Sea Link Energy Cable

**Appendix E7 to the Natural England Deadline 7 Submission
Natural England's Intertidal and Benthic Ecology Advice**

Planning Inspectorate Reference EN020026

29th April 2026

Figure showing Offshore Scheme (red) and subtidal chalk habitat (green)

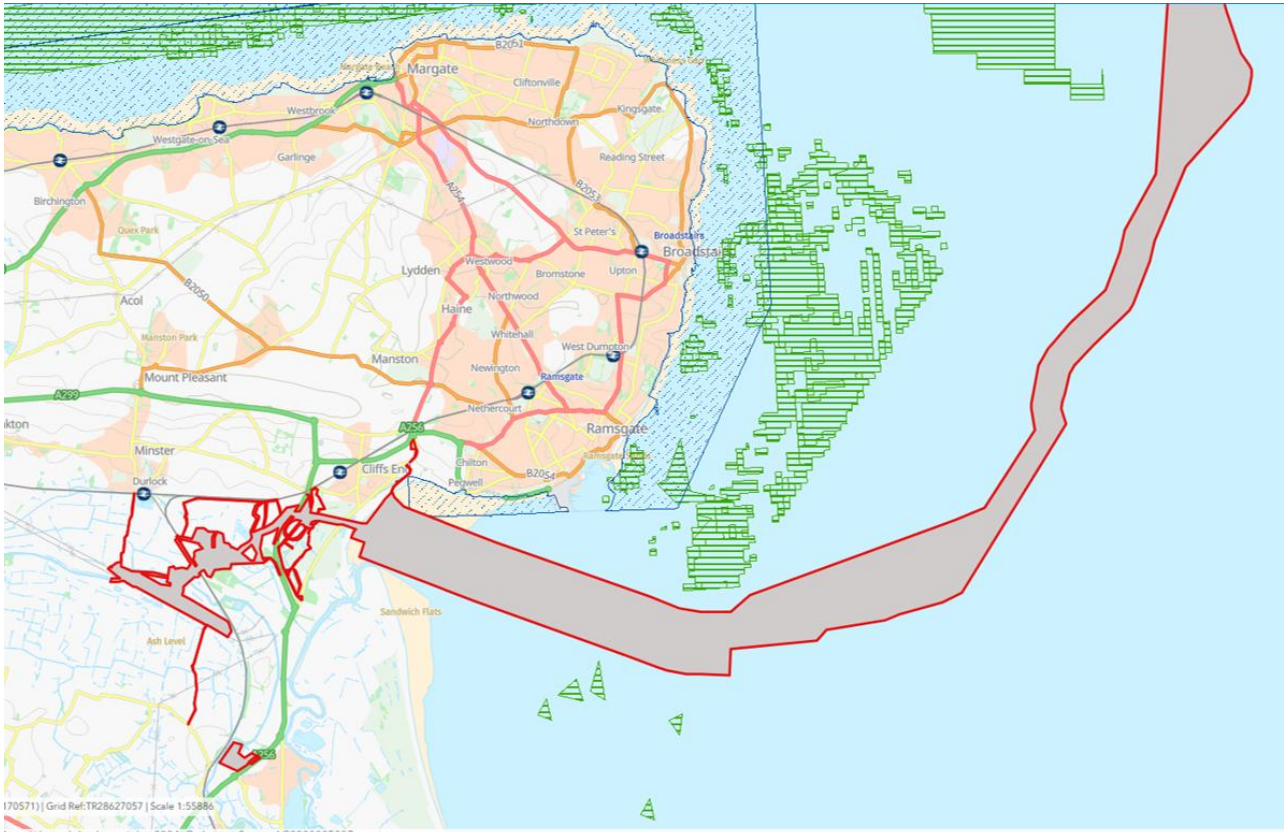
2	2.9.25	<p>Natural England questions the statement that the only surficial chalk was identified between KP101 and KP127, and the remaining was subsurface.</p>	<p>Natural England advises that clarification is provided regarding the extent and distribution of subtidal chalk across the whole of Offshore Scheme.</p>

The referenced Geophysical and Geotechnical survey report (REP2-035) states that chalk outcropped between KP96 and KP98.	
3	2.9.9-2.9.10	<p>Natural England welcomes the change to the sensitivity of peat and clay exposures (a S41 NERC and irreplaceable habitat) to physical disturbance to 'high', as advised by Natural England previously.</p> <p>However, Natural England notes that no sensitivity information is provided for physical disturbance impacts to subtidal chalk.</p> <p>The proposed changes partly address concerns within Point 5 of the Benthic R&I Log. However, the changes have only been made for peat and clay exposures and the sensitivity rating for subtidal chalk has been deleted.</p>	Natural England advises that the document should be updated to include a 'high' sensitivity rating for subtidal chalk to physical disturbance impacts.
4	2.9.19	<p>Natural England notes the additional information provided regarding the movement of plant and vehicles cross the mudflats at Pegwell Bay, including the statement that any indentations upon the mudflat surfaces will be undetectable after a single, or at most, a few tidal cycles.</p> <p>Natural England welcomes this statement but advises that monitoring is required to validate this statement.</p> <p>In addition, there is no consideration of compaction of sediment which can impact the underlying sediment and effect the accretion of Saltmarsh in the future.</p>	Natural England advises that post-consent monitoring is secured to monitor the recovery of the intertidal mudflats morphology and biological communities following landfall construction works, to validate predictions within the ES. This issue could be considered resolved if appropriate monitoring is secured through the IPMP.
